Heckington Fen Solar Park

EN010123

Applicant Response to Deadline 3 Submissions

Document Reference: ExA.ResponseD3Sub-D4.V1

FIGURE 3.8 – Extent of Plantation clearance in Additional Works areas at Bicker Fen National Grid Substation

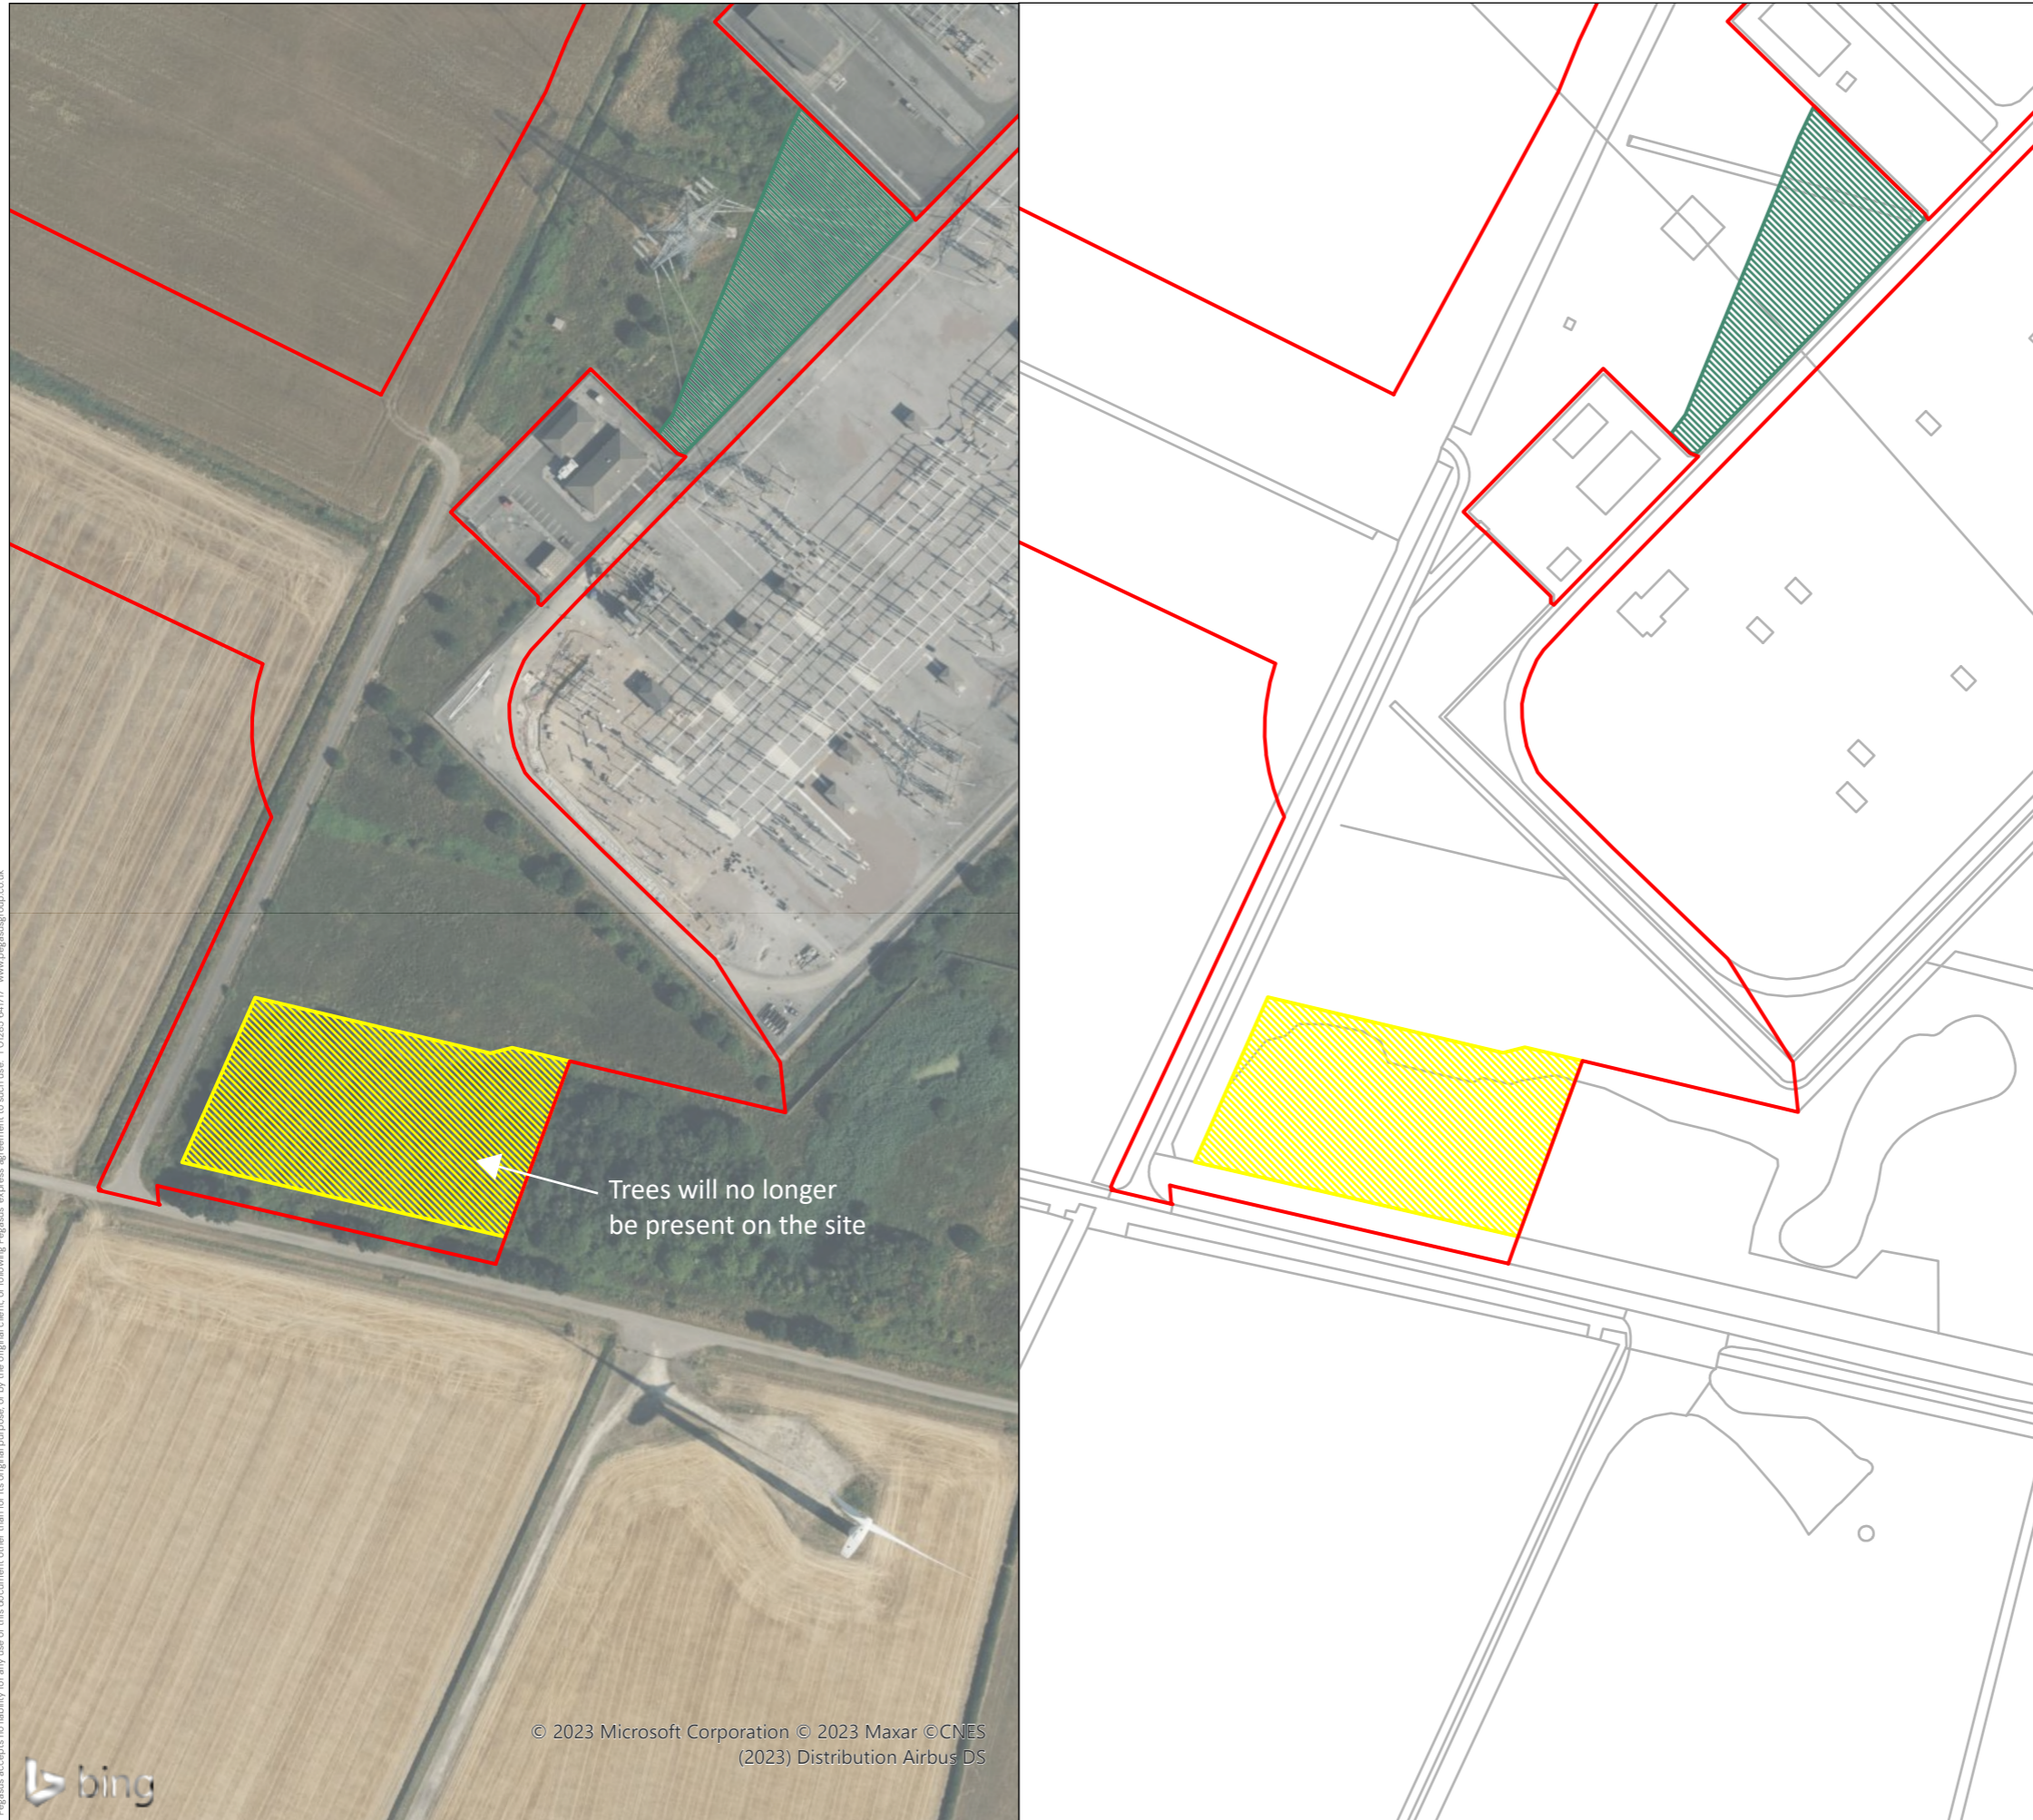
Theme	BBC Comment	Applicant Response
	county wide habitat connectivity and recovery.	
REP3-049 BBC Response to Action Points from ISH3		
Planting at Bicker Fen Substation	The Forestry Commission operate at a national scale and at that strategic level replacing the trees at the solar park site is a reasonable point of view. However, locally it does not address the level of tree cover in Boston Borough. The applicants have continued to work on this issue and have drafted amended wording to be inserted into the Outline Landscape and Environmental Management Plan. BBC are happy with this approach.	The Applicant welcomes this confirmation from BBC that they are happy with the commitment in the oLEMP to offset the tree loss from the Bicker Fen Substation, and the Applicant concurs with the position. This position is further agreed in the Statement of Common Ground (document reference 7.6a, Version 3).
